Request for review of Bess and solar regarding wrong FRA assessment

Formal Objection to the Fenwick Solar Farm Consultation: Flood Risk and Climate Change Allowance Non-Compliance

Submitted to: National Infrastructure Planning Consultation for Fenwick Solar Farm

Date of Submission: June 18, 2025

FIGURE NUMBER
Figure 9-3-6a

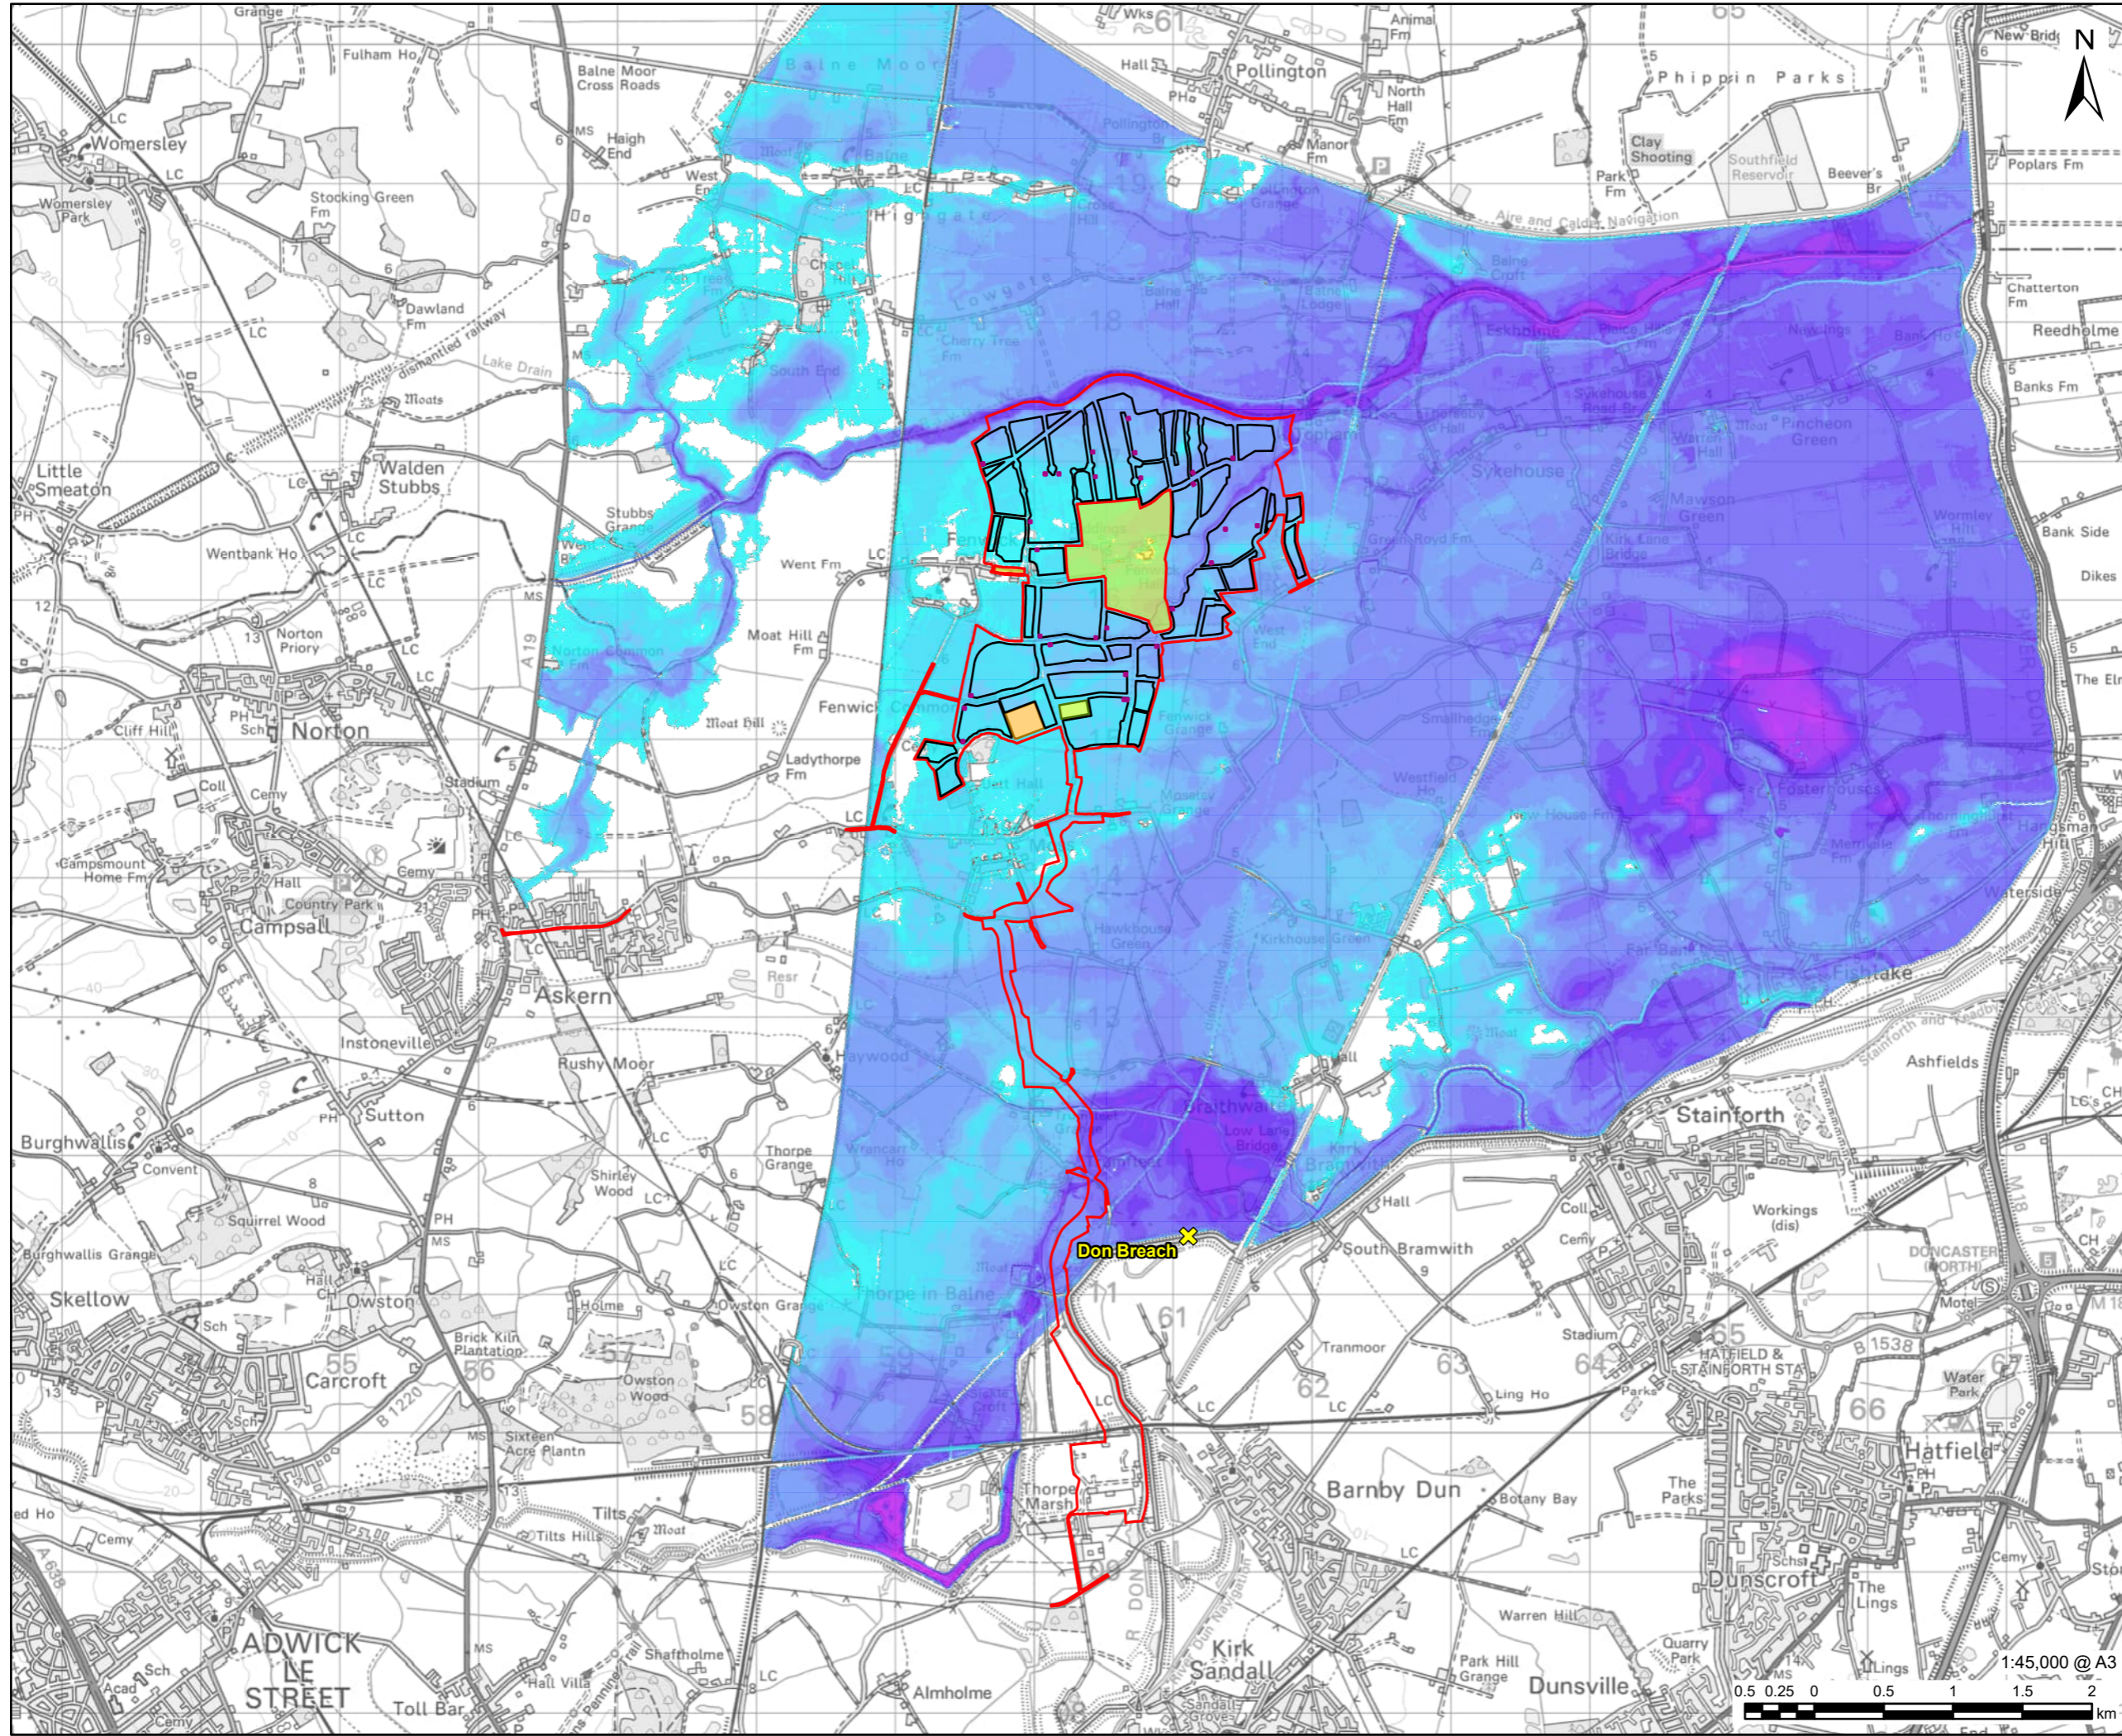
Although the developers claim the BESS is located within Flood Zone 1, the FRA identifies significant areas of the site as falling within Flood Zones 2 and 3. Furthermore, even in Flood Zone 1, the Environment Agency's breach modelling for the River Don indicates potential flood depths of up to 0.85m in the event of a failure.

Plate 1: BESS Area Proposed Design

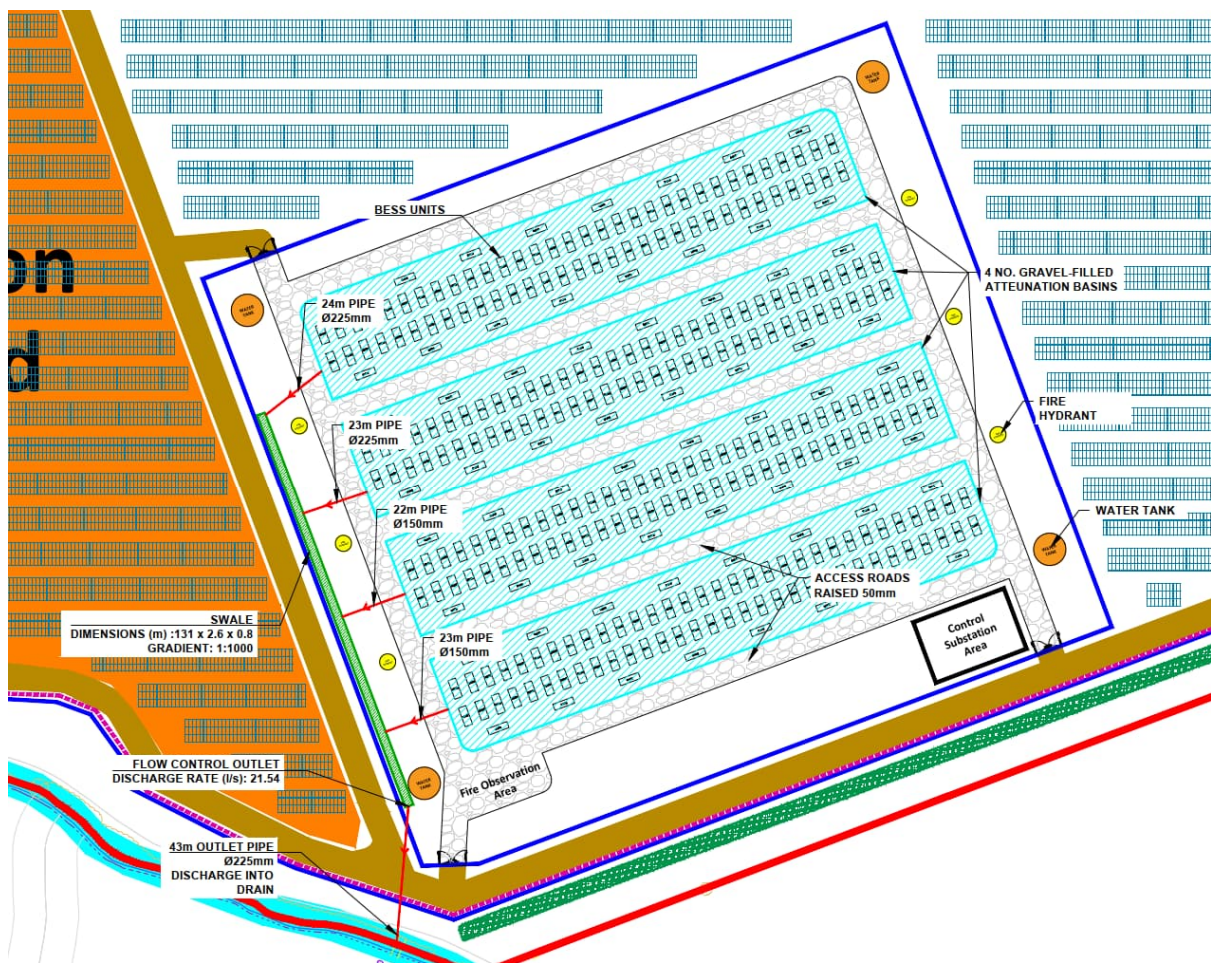
While the scheme includes bunds (e.g. 1.15m bunding for the BESS platform), these are based on outdated flood scenarios. The drainage infrastructure-including swales, attenuation basins, and soakaways-has been designed using lower rainfall assumptions. This leaves the site vulnerable to increased runoff volumes and flood depths under updated EA projections.
